## Development Facilitation Team (DFT) – Review Comments

Project No: PR-2023-005597      Date: 05/10/2023      Agenda Item: #2 Zone Atlas Page: G-11

Application For: SD-2023-00092-FINAL PLAT (DHO)

**Project Name:** Lots 1 Thru 10, The University of Albuquerque Urban Center

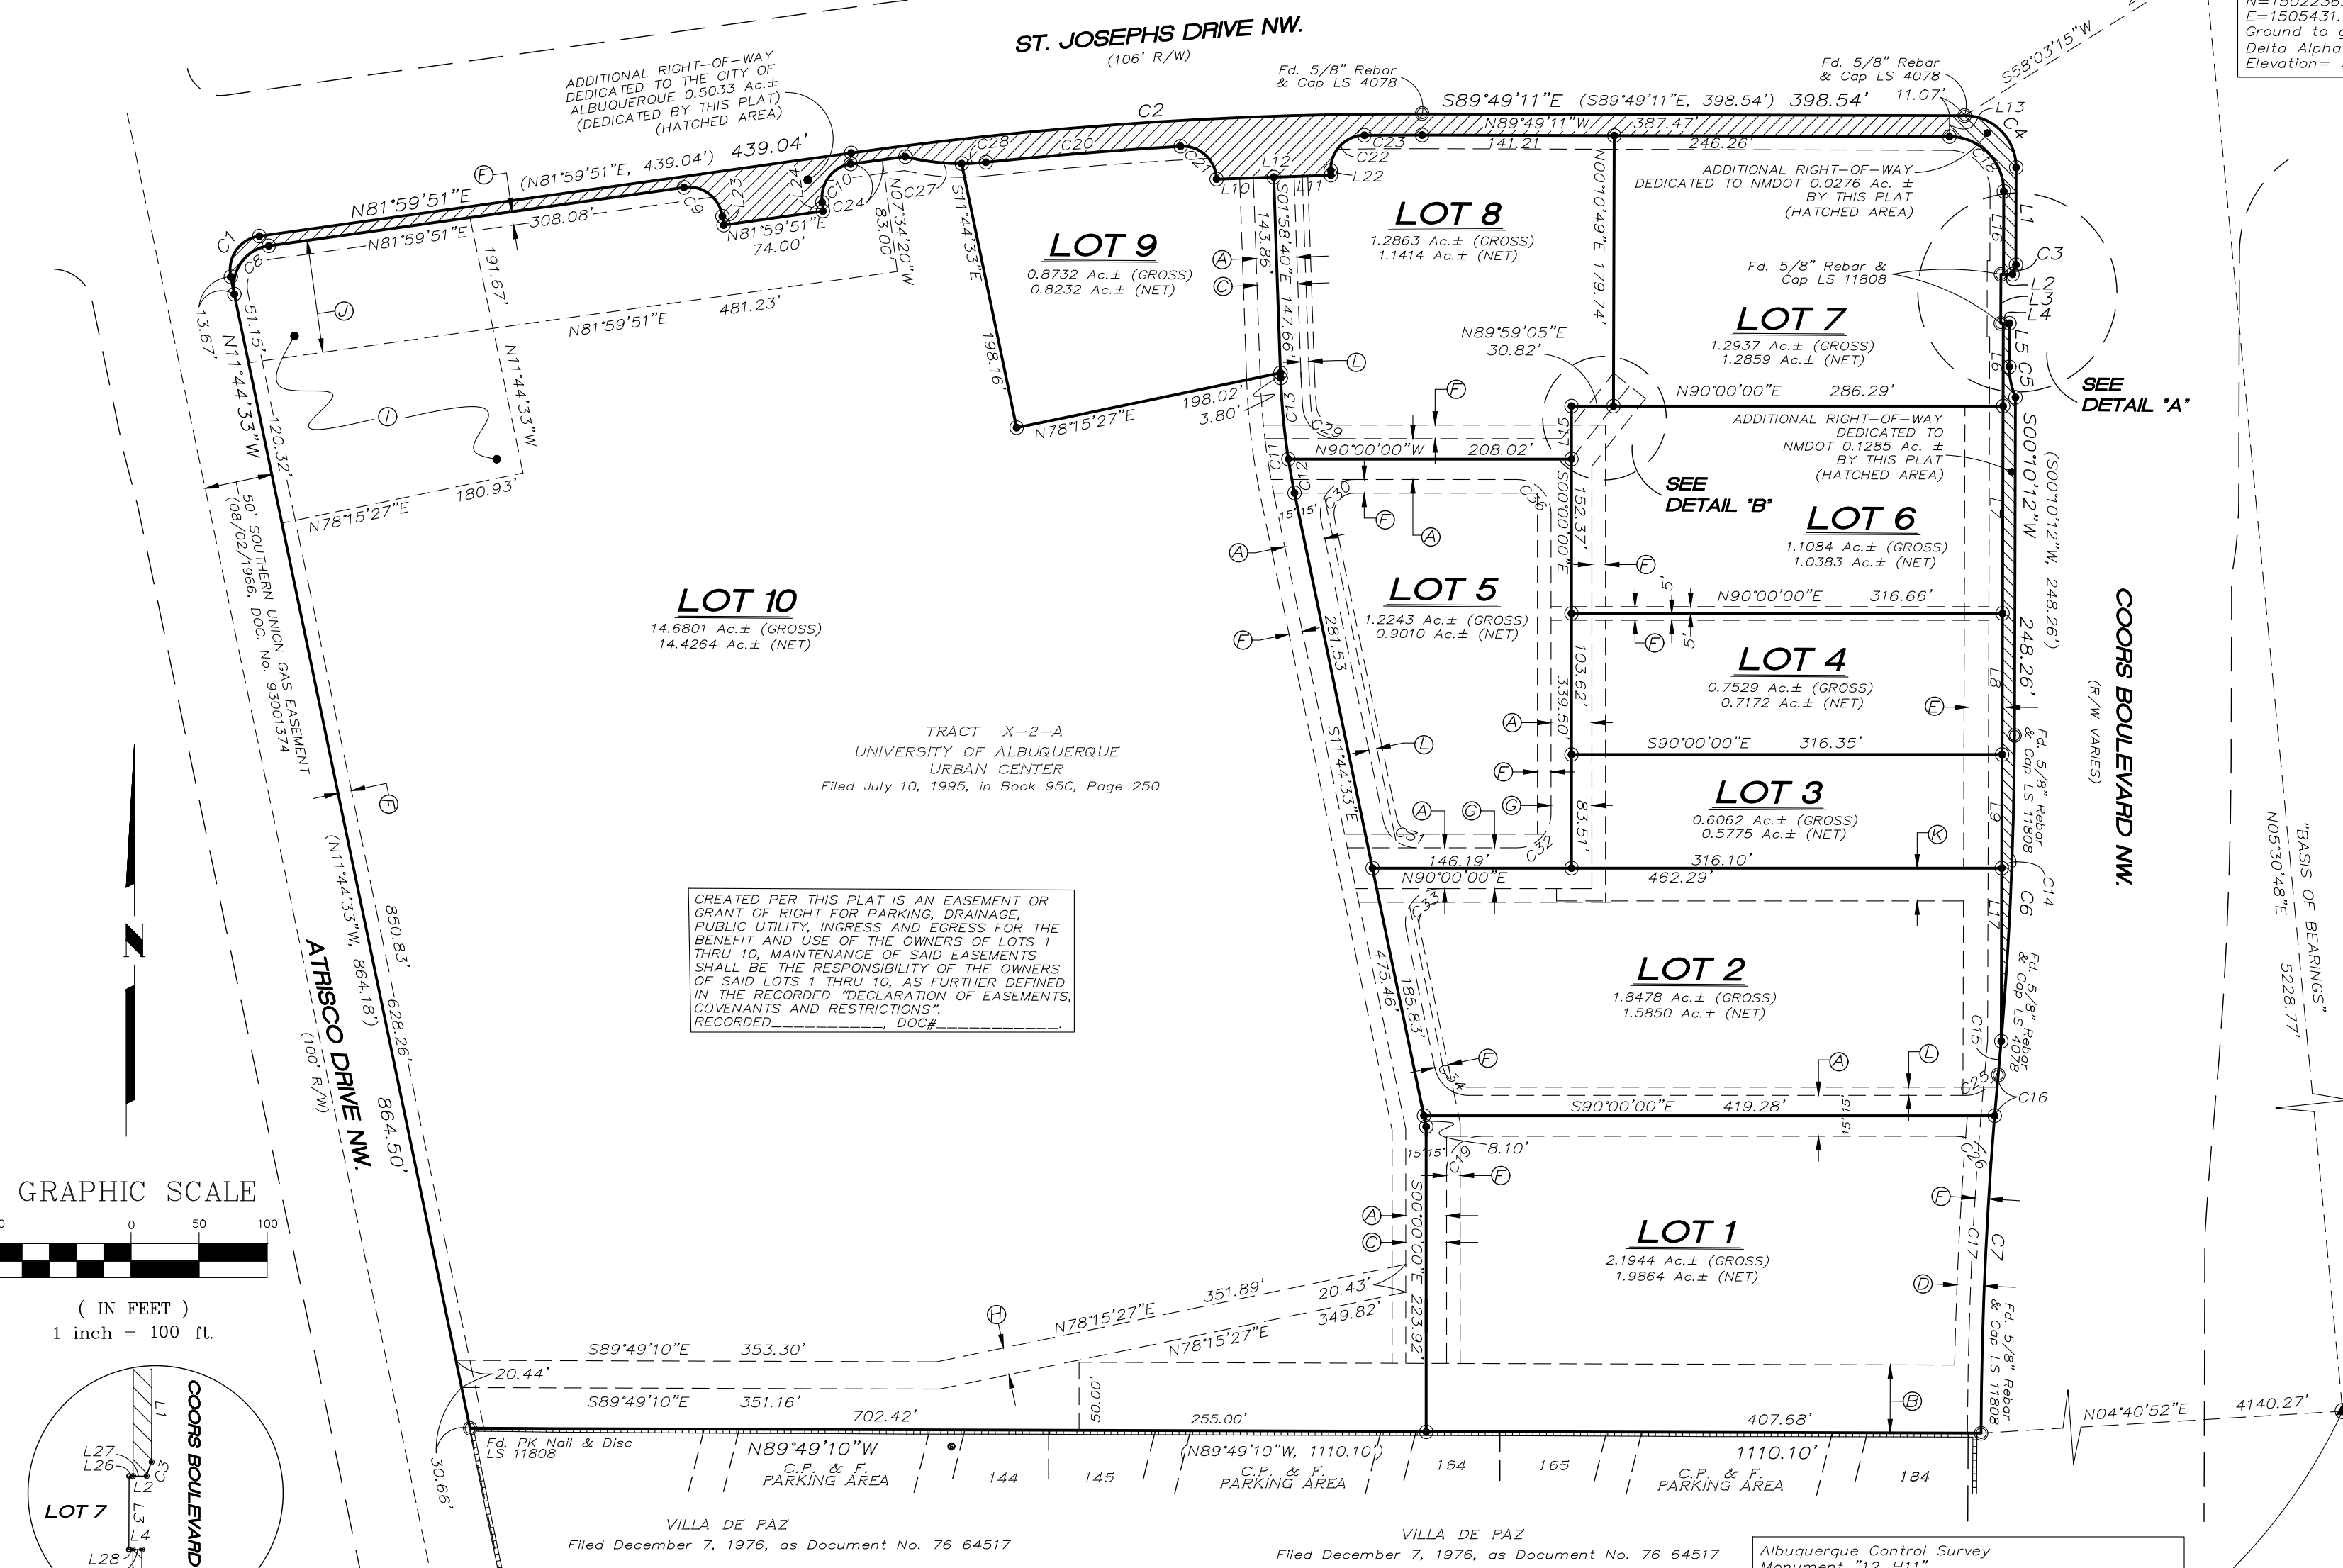
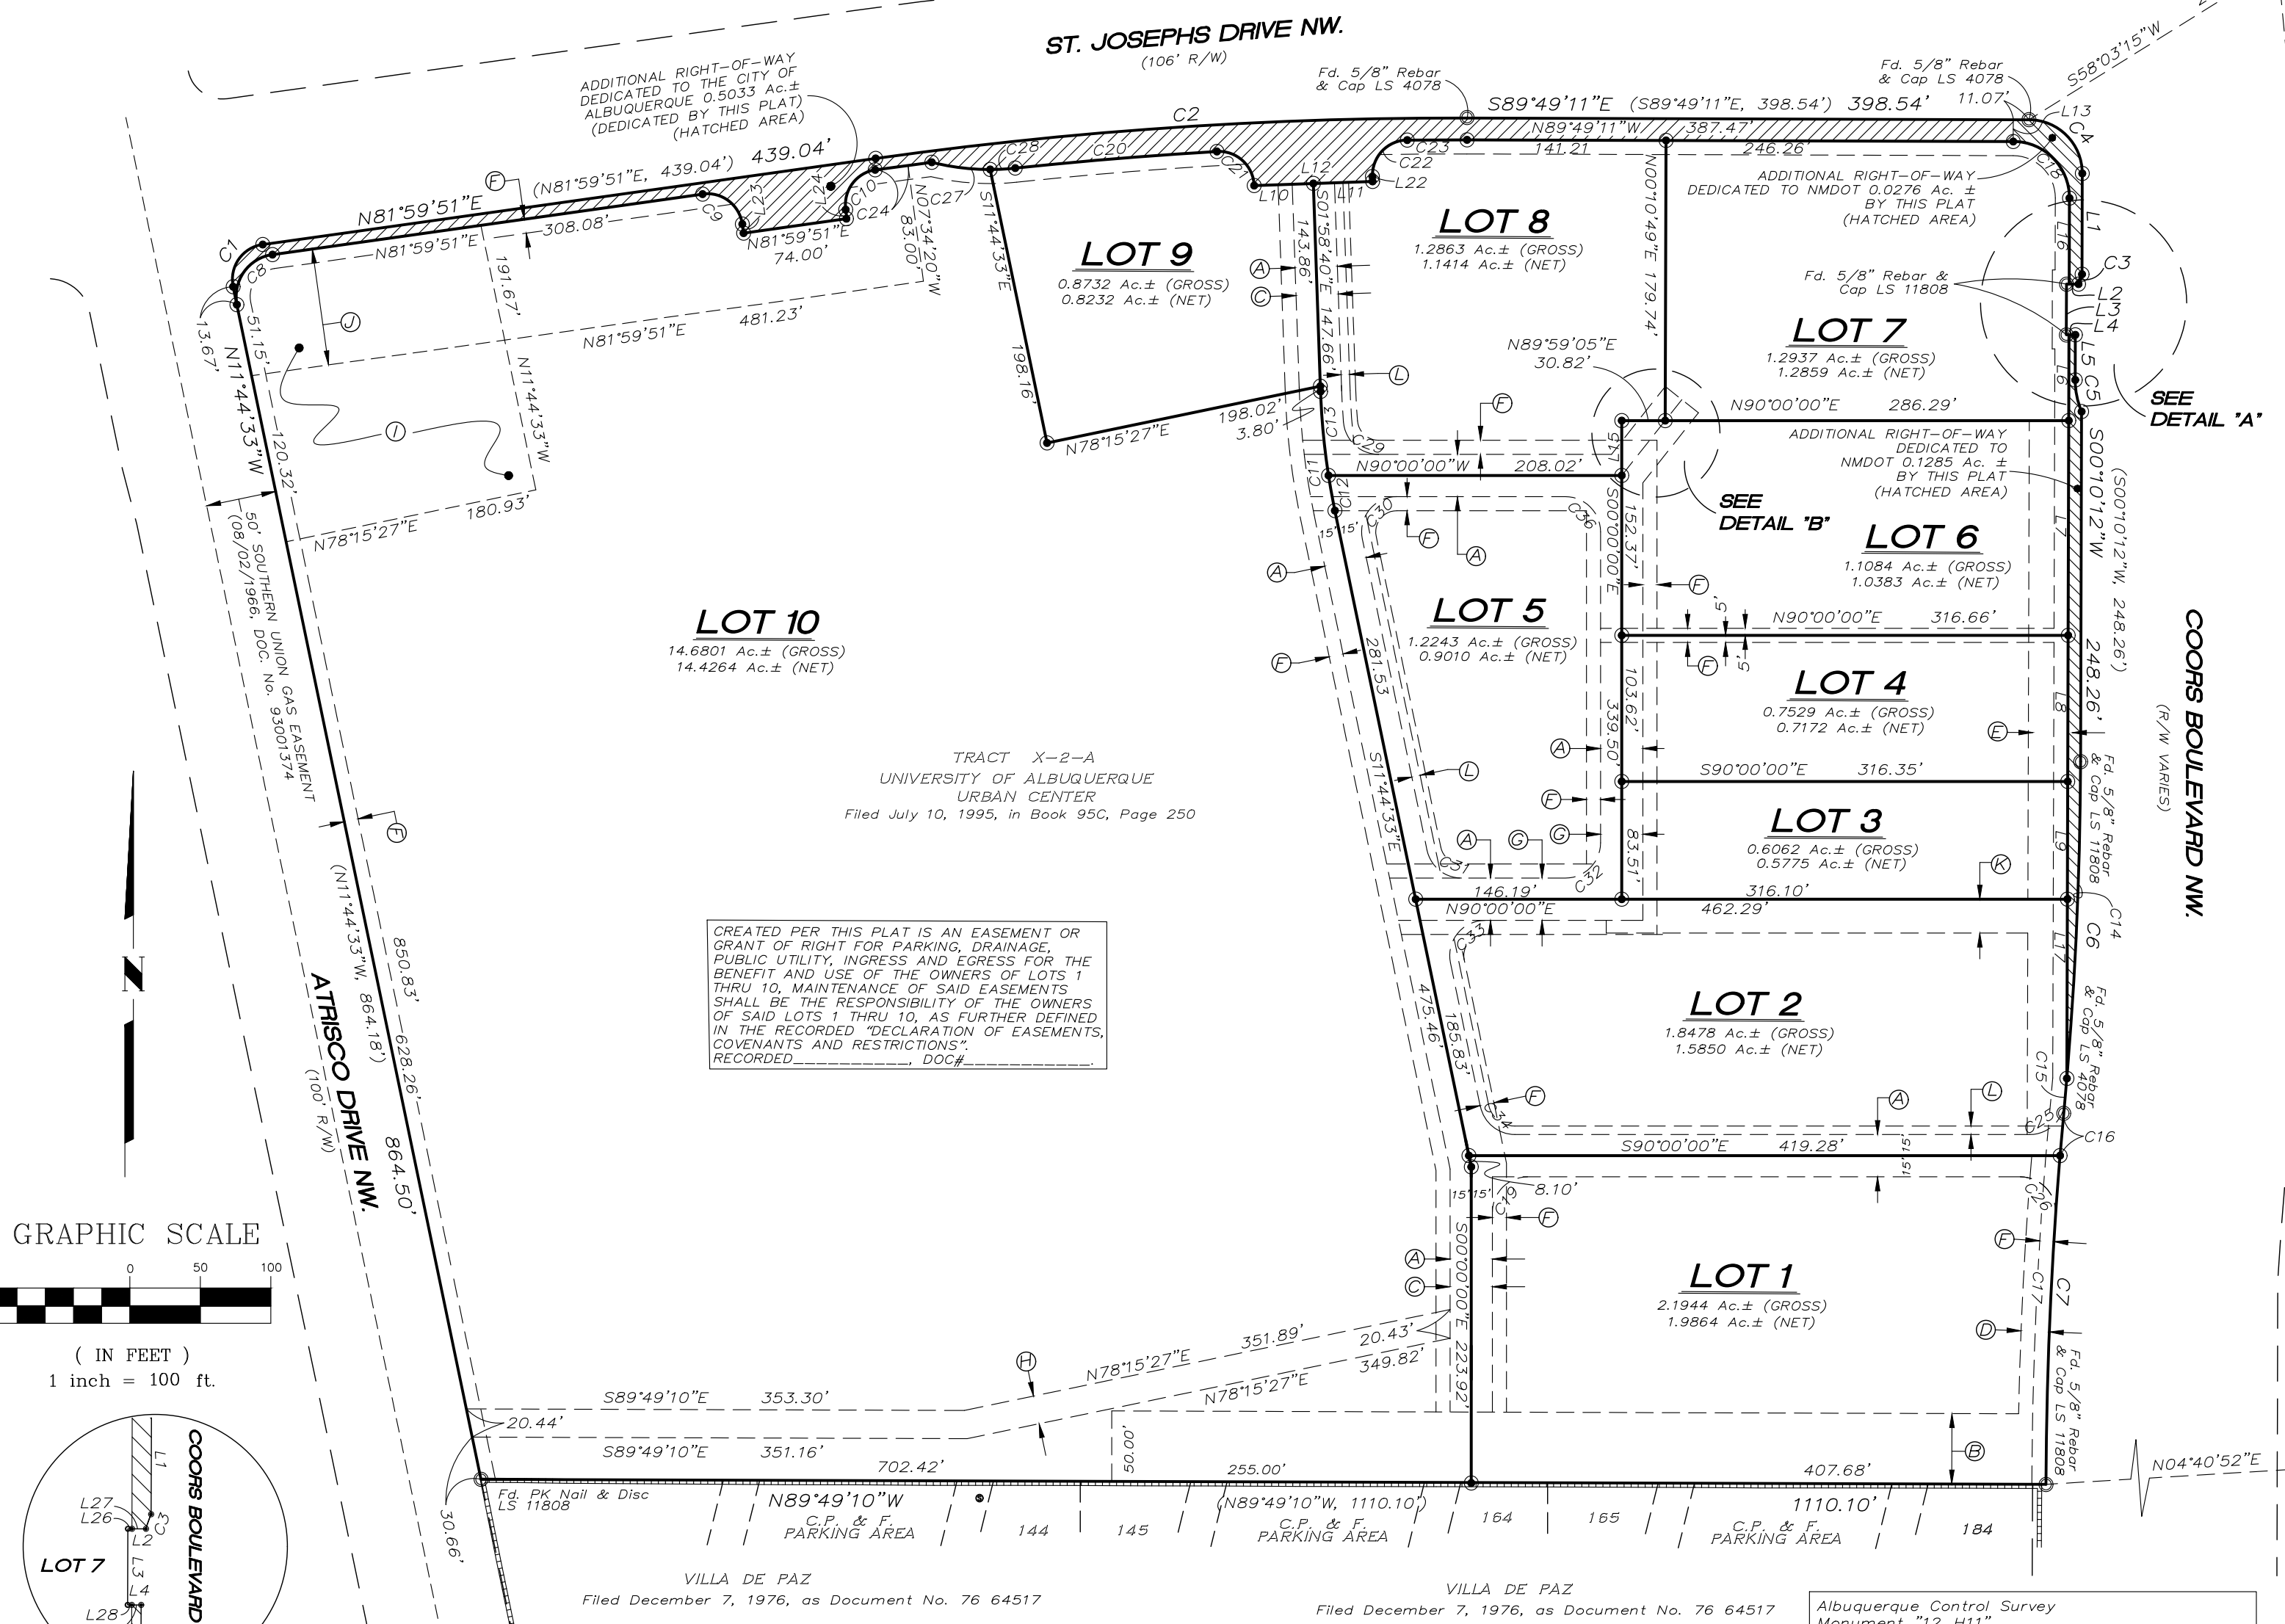
- The application number on the Plat must be corrected to SD-2023-00092.
- The DXF file must be approved by AGIS, and the approval email from AGIS must be submitted prior to final sign-off from Planning should the Plat be approved by the Development Hearing Officer.
